Our Ref: BTC00
Your Ref:
Date: 12th February 2021

**DEADLINE 3 – APPLICATION BY HIGHWAYS ENGLAND FOR A DCO FOR THE A1 IN
NORTHUMBERLAND – MORPETH – ELLINGHAM
COMMENTS ON RESPONSES SUBMITTED FOR DEADLINE 2**

Drawing Number: HE551459-WSP-ELS-A2E-DR-LE-1817
Revision: P04
PW Stage Code: 0

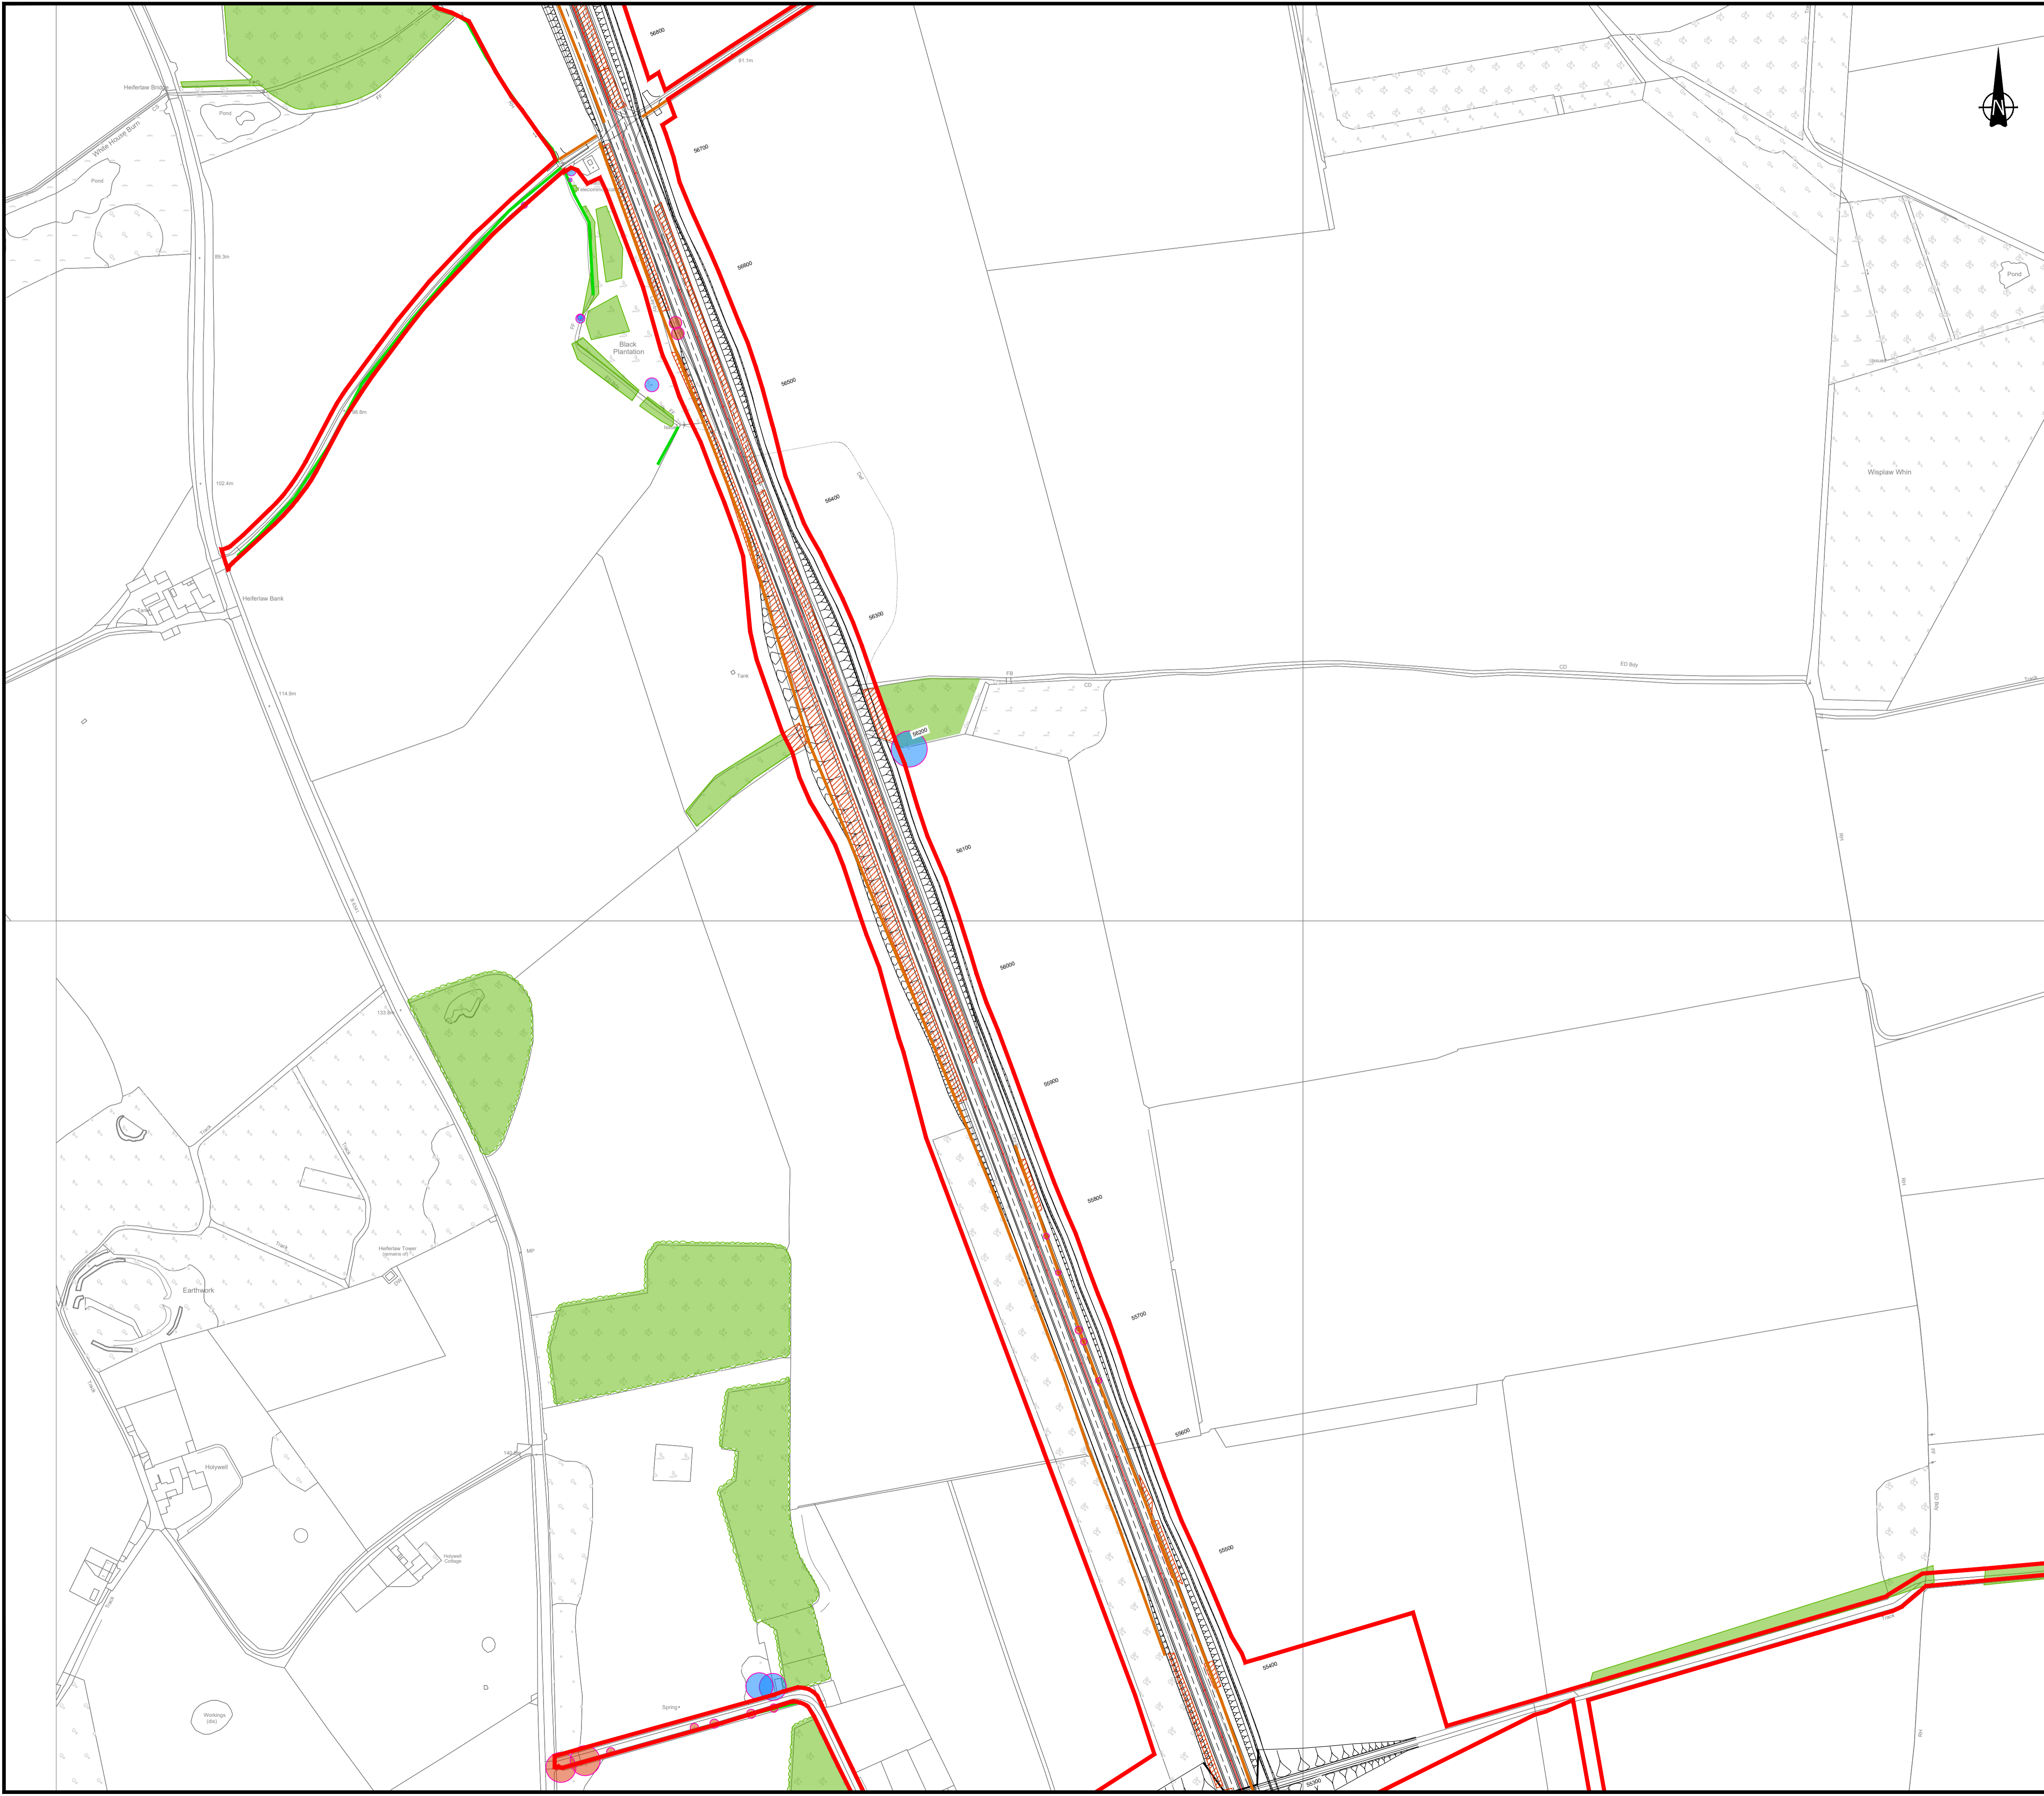
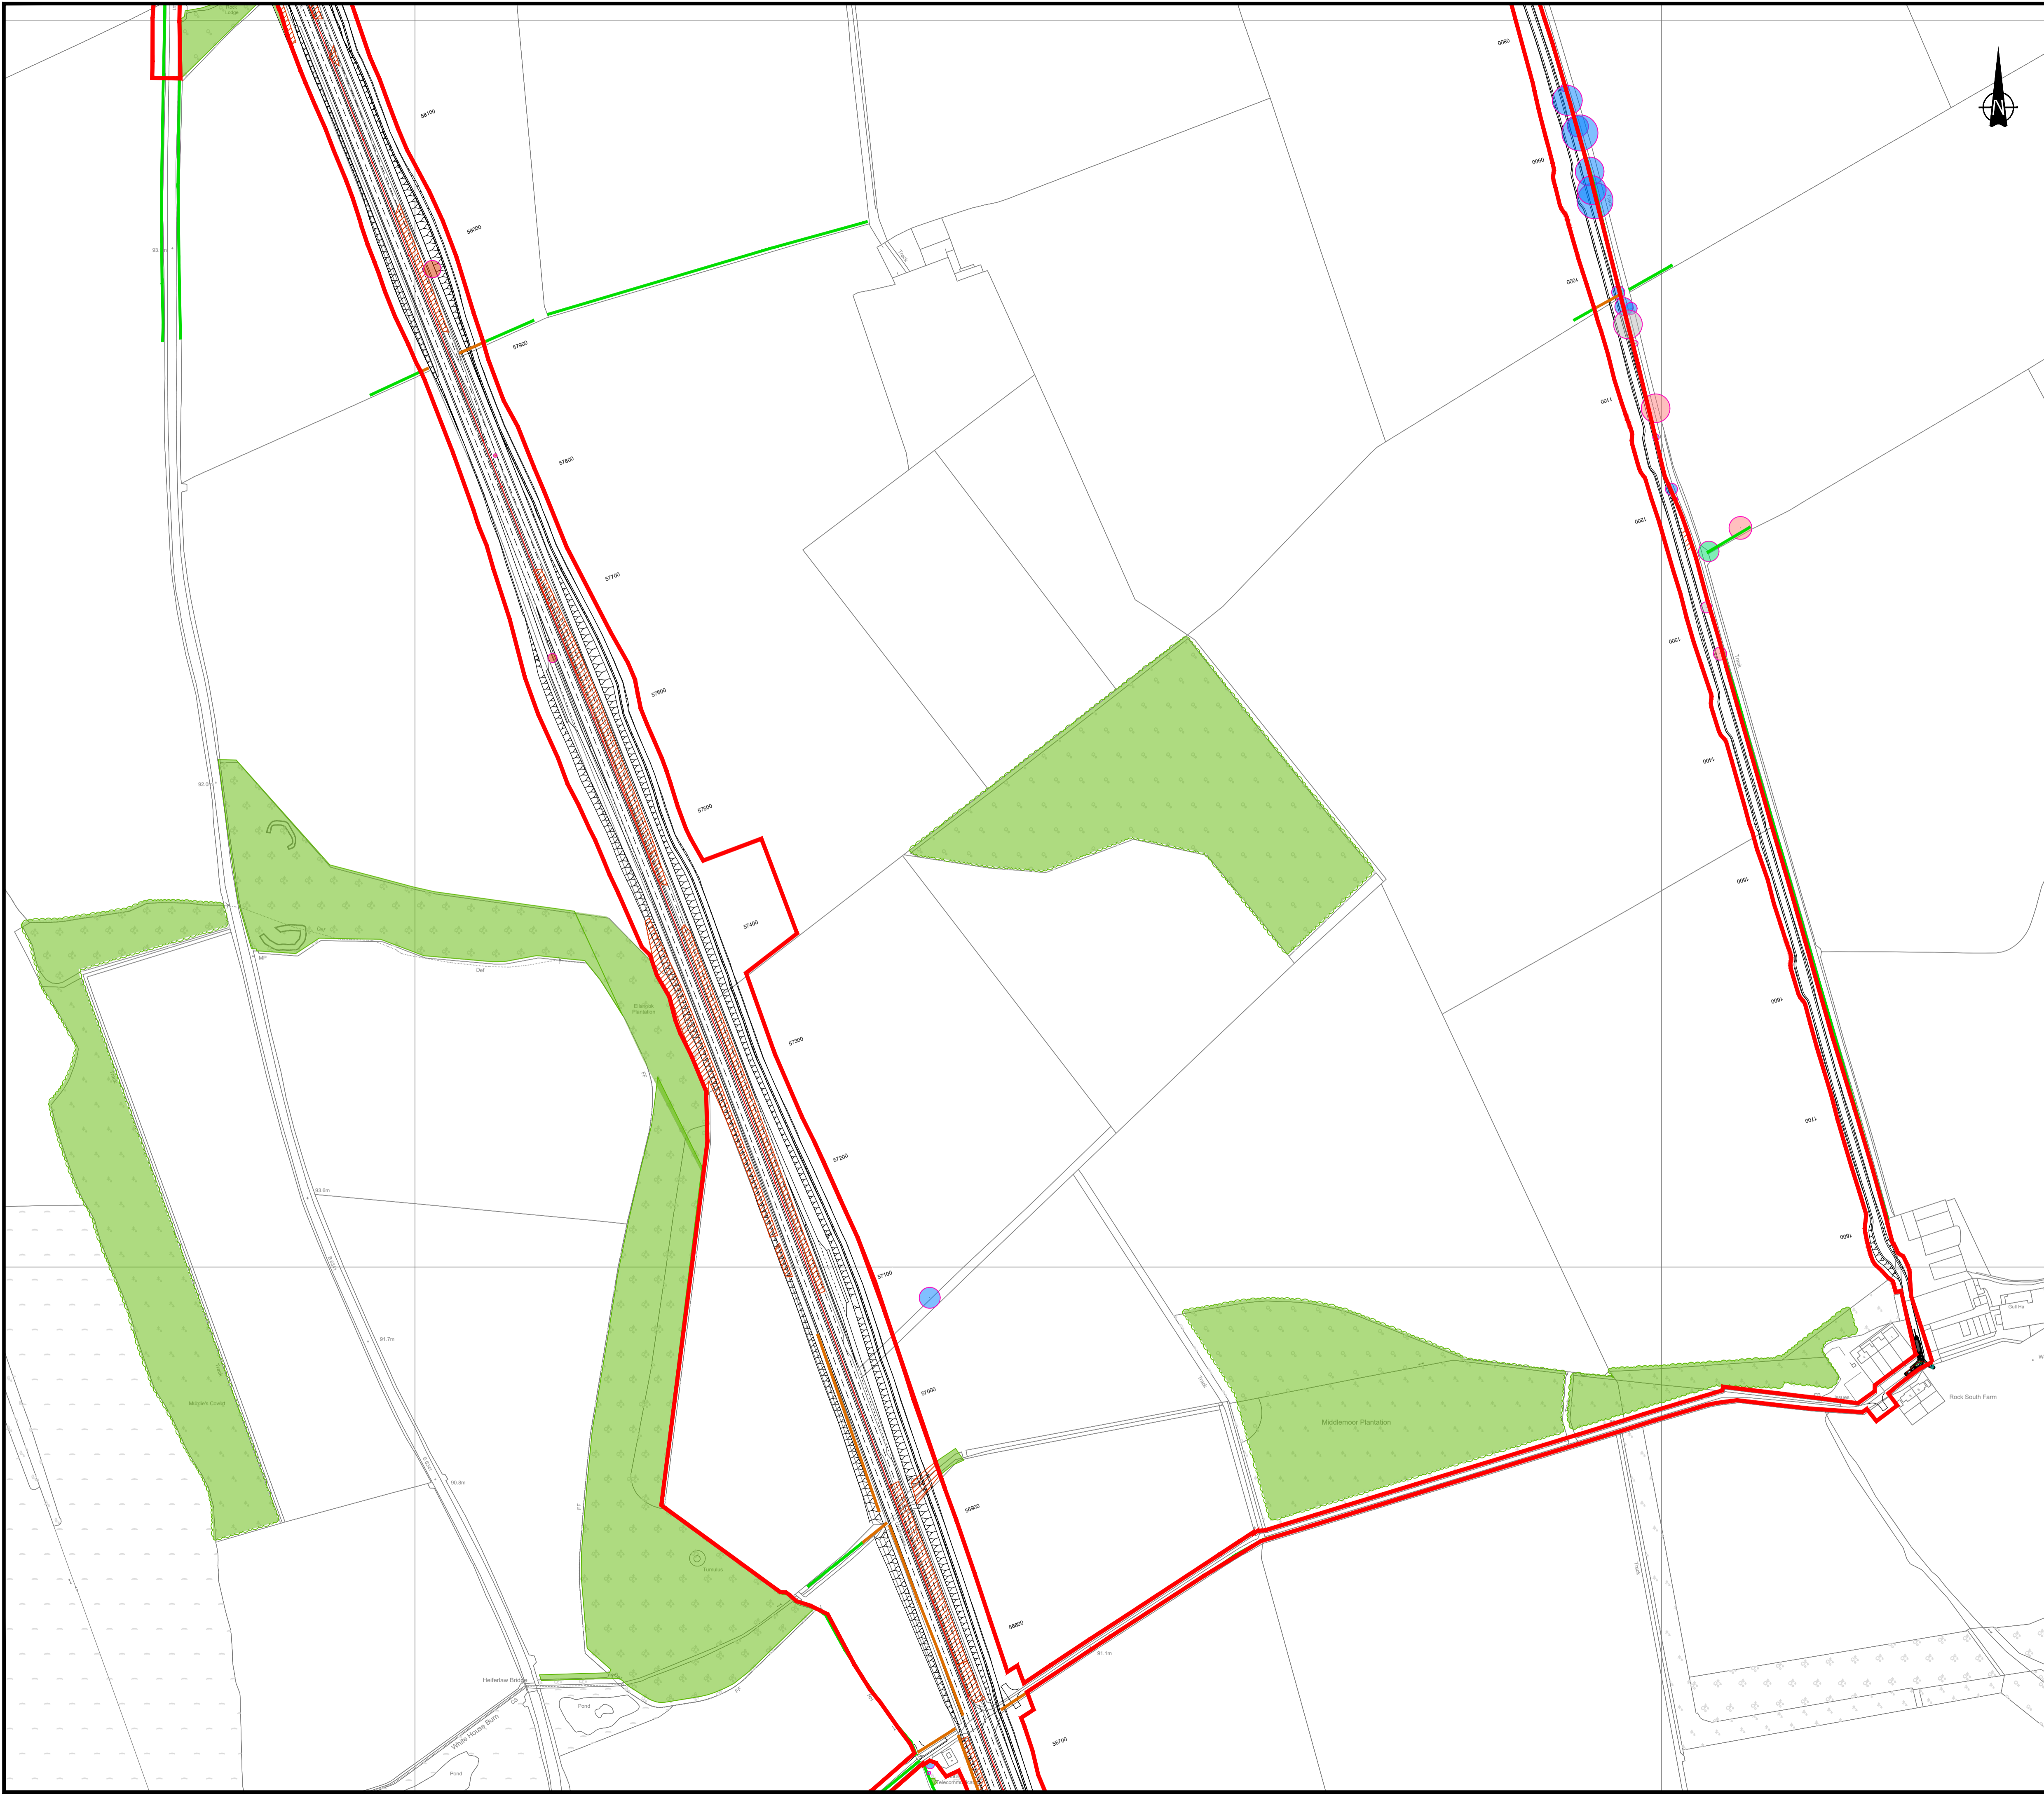
1. Vegetation Clearance –we note submission of Document TR010059 – 001182 6.6 ED Part B Figure 7.11. The document states that vegetation in front of West Linkhall Farm and West Lodge at Charlton Hall is to be removed. We have had verbal confirmation that this is not the case and that whilst some maybe removed, not all of it will be. We are concerned that the DCO is assuming the full removal and we would contest that this is not necessary following conversations with HE and their representatives.
